**ADC Planning Consultation
Response from the Conservation Officer**

Application Number	AB/76/14/PL
Address	1 Quay House River Road Arundel BN18 9DF
Description	Awning to North & East elevations. This application affects the character & appearance of Arundel Conservation Area
Case Officer	Mrs. A Gardner

PROPOSED ELEVATIONS 1:100

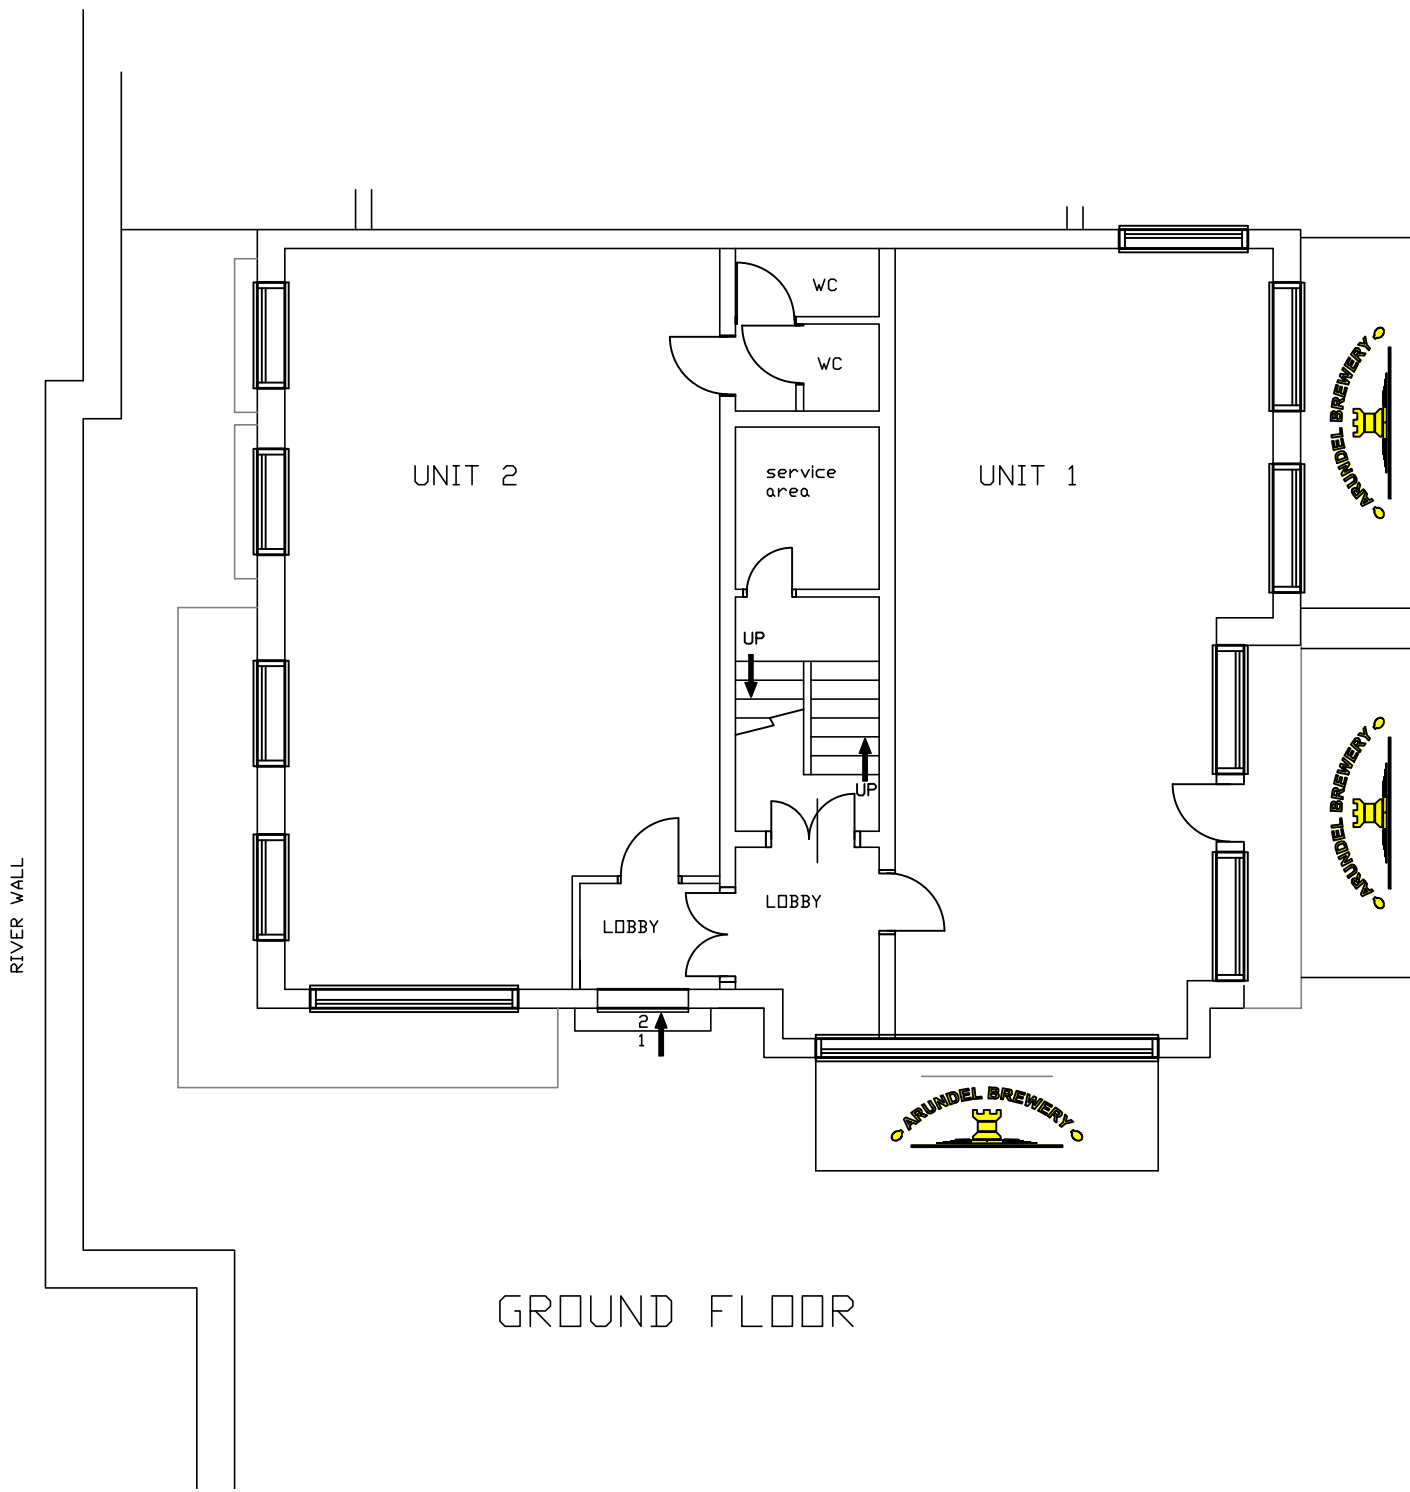
The proposal is for a number of canopies on a corner property. As the property is located on a corner at the base of the high street, it has the potential to have an impact upon the conservation area.

Having viewed the information can it be confirmed if the canopies will always be projecting out, or will they only be used during certain time periods? Careful management of the canopies so that they are not always left out will be supported.

It is considered that the colour of the canopies and the design upon them are acceptable to the property and local area, and will not have a negative impact upon the character or appearance of the conservation area.
